Re: Observation on Strategic Infrastructure Development application for the proposed Littleton Wind Farm, Co. Tipperary - Case Reference: PCX92.311587

Applicant: Littleton Wind Farm DAC (a joint venture of SSE Renewables and Bord na Móna Powergen Ltd)

I am writing to formally object to the above proposed Strategic Infrastructure Development, comprising 11 no. wind turbines (200m blade tip height), an onsite 110kV electrical substation, a permanent meteorological mast, an onsite borrow pit, peat and spoil deposition areas, internal access tracks, recreational amenity trails and all associated works at Littleton, Longfordpass, Lanespark, Ballybeg and Derryvella Bogs, Co. Tipperary, together with the accompanying Environmental Impact Assessment Report (EIAR) and Natura Impact Statement (NIS).

Route Screening Assessment (RSA) - Screening Classification

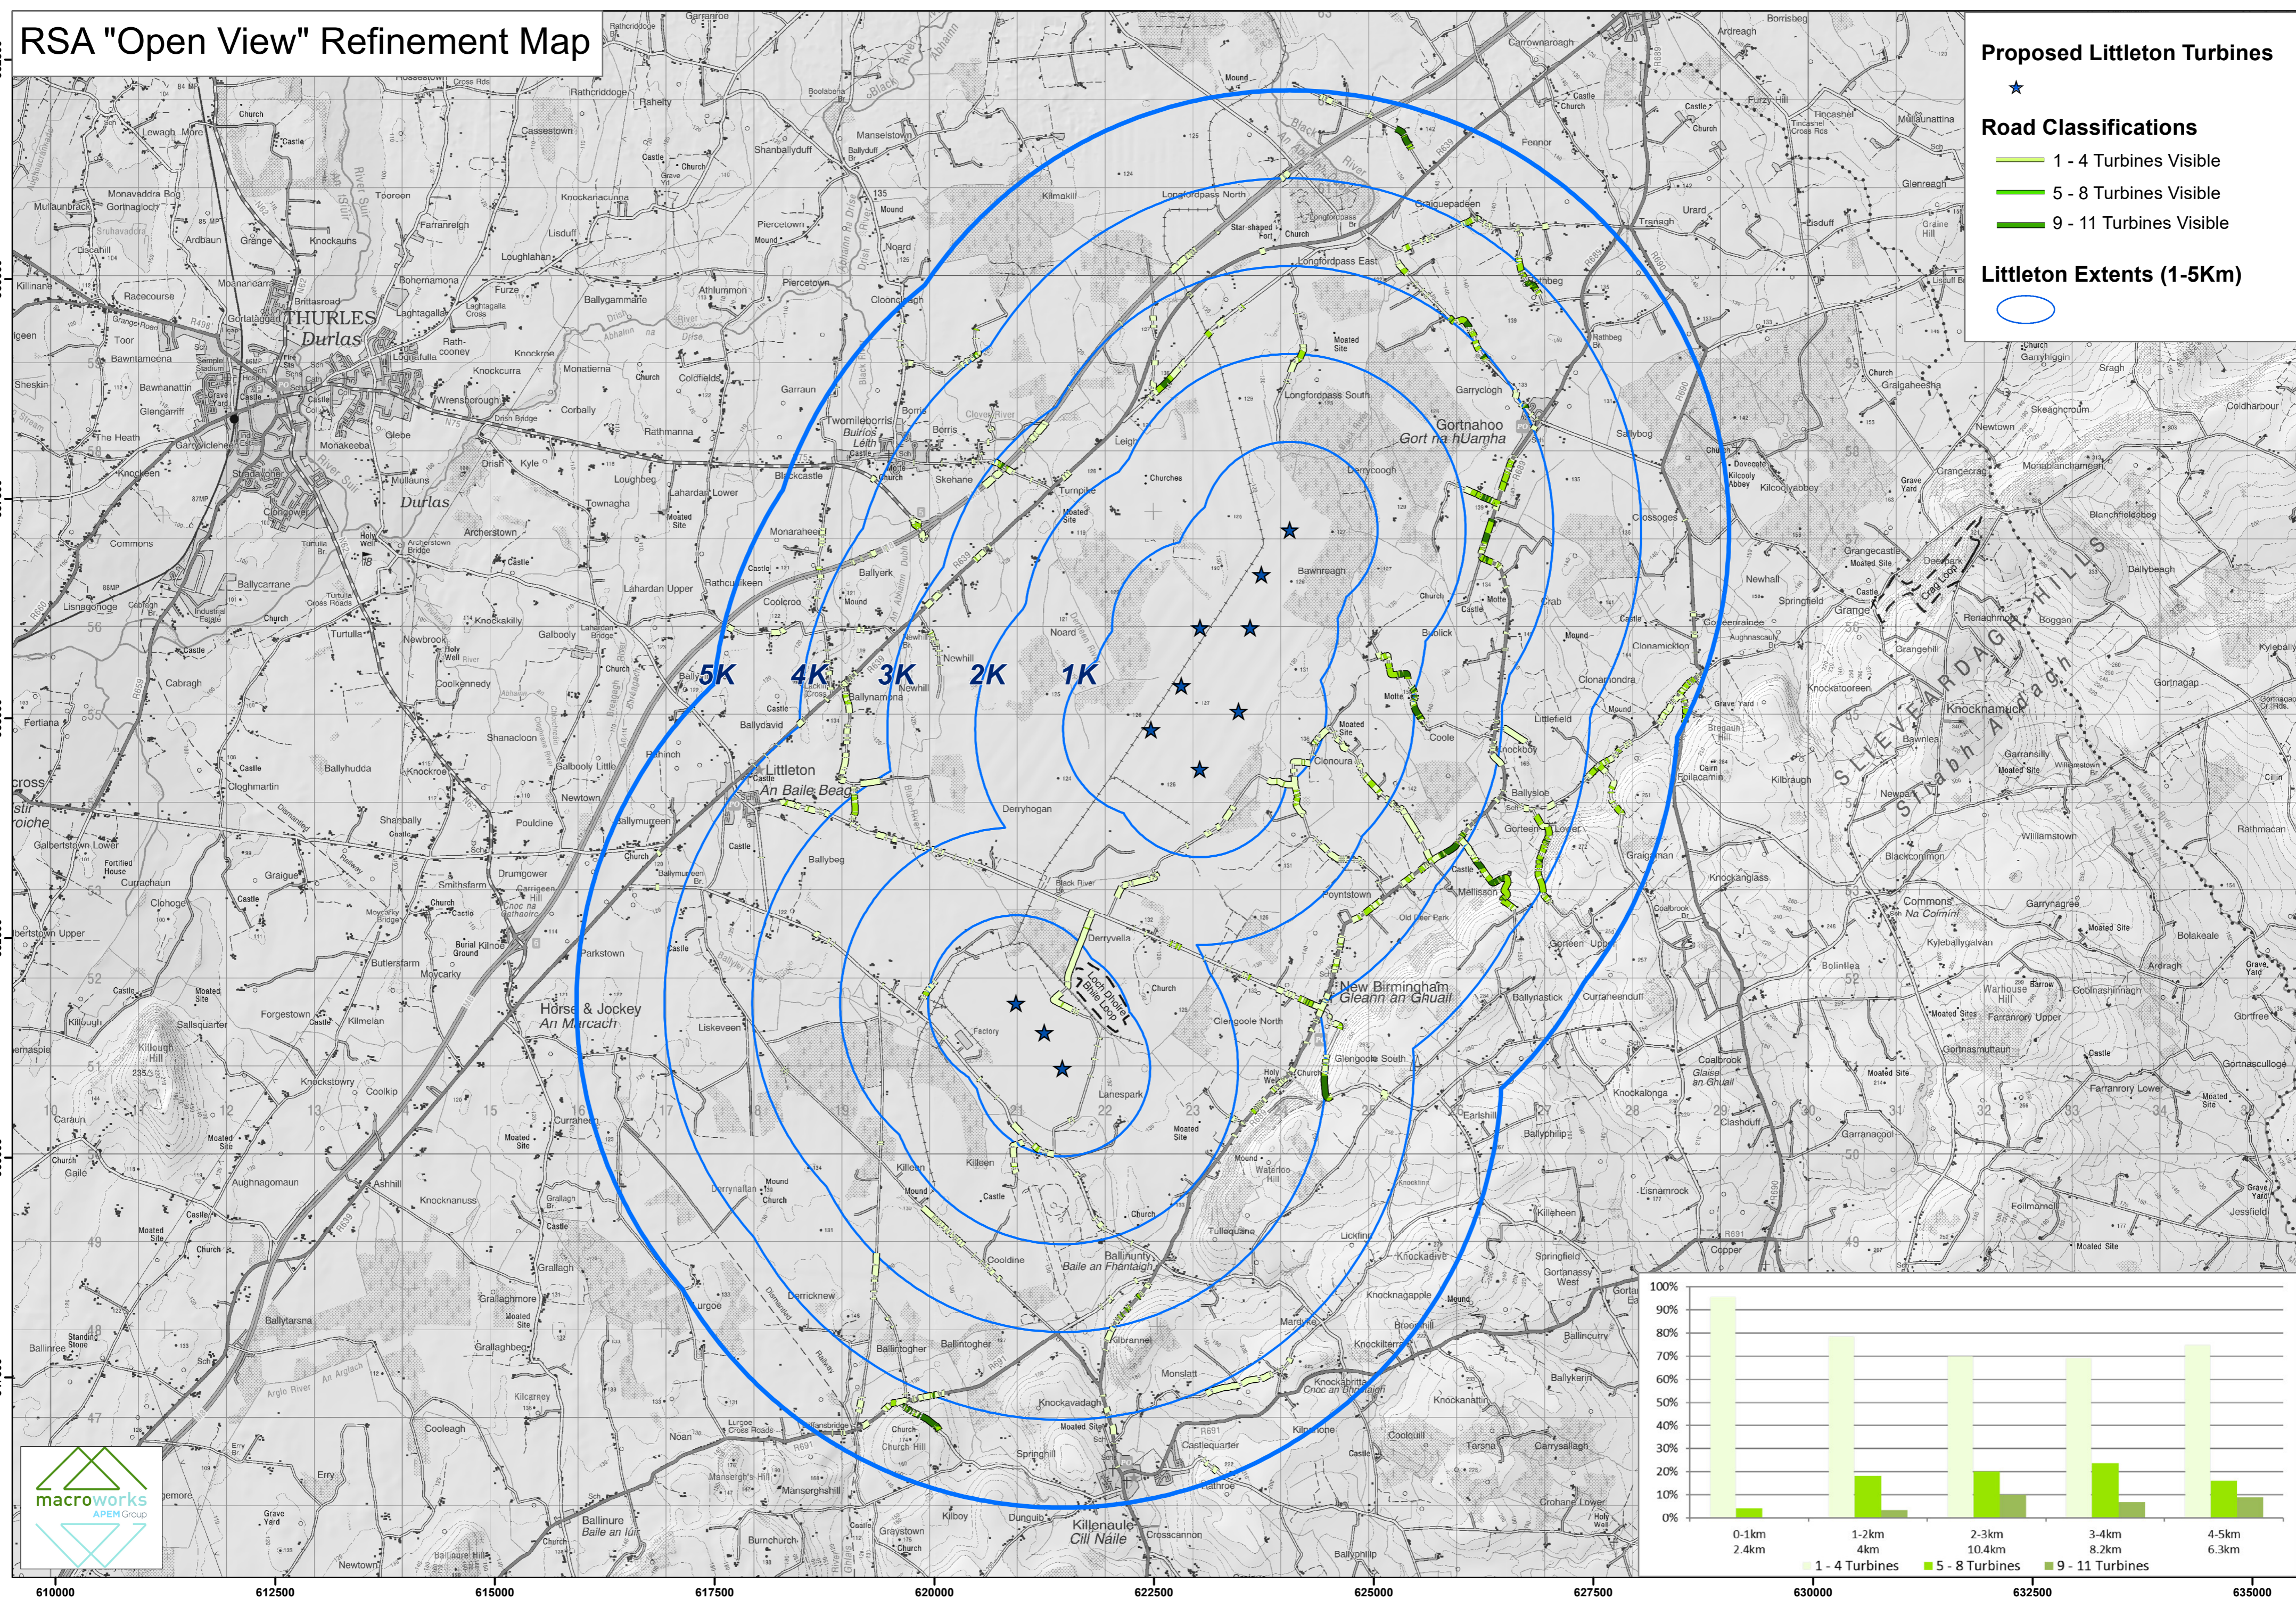
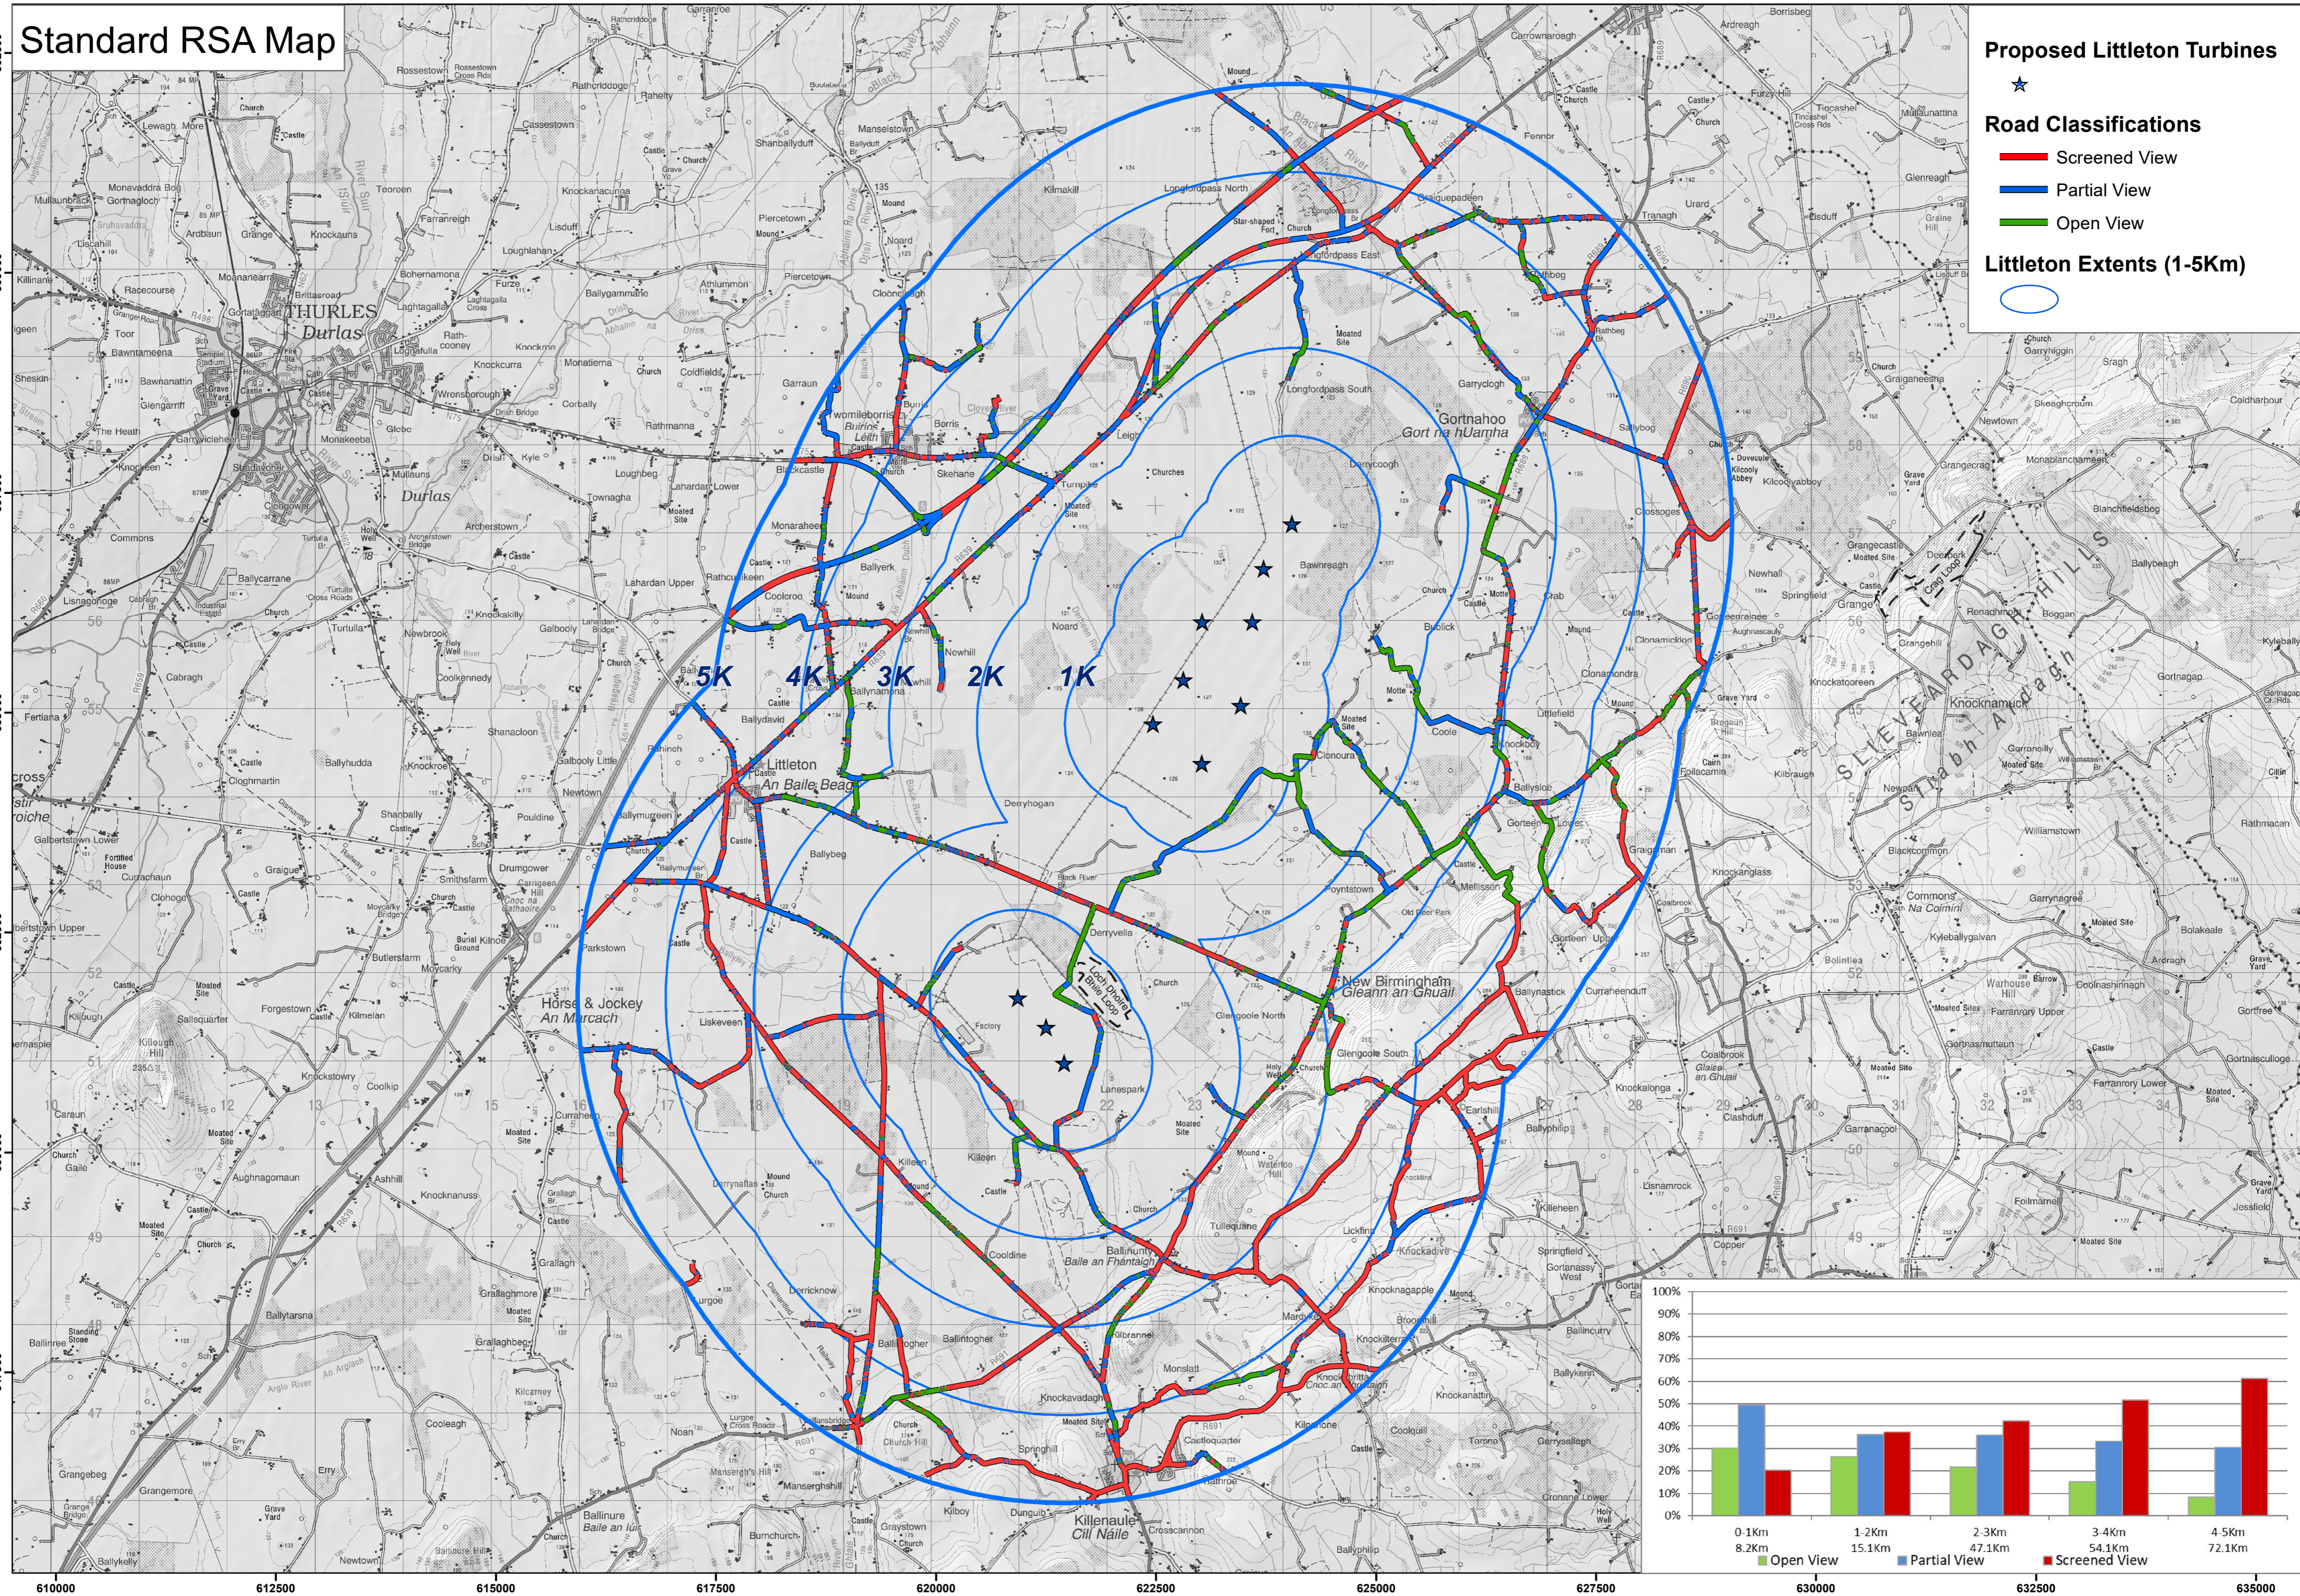
- The applicant's own Route Screening Analysis admits that open, largely unscreened views of nine to eleven turbines together will be visible from a 4-5km band east of the site, between New Birmingham and Gortnahoe. This contradicts any claim that the development would be well screened from sensitive viewpoints.
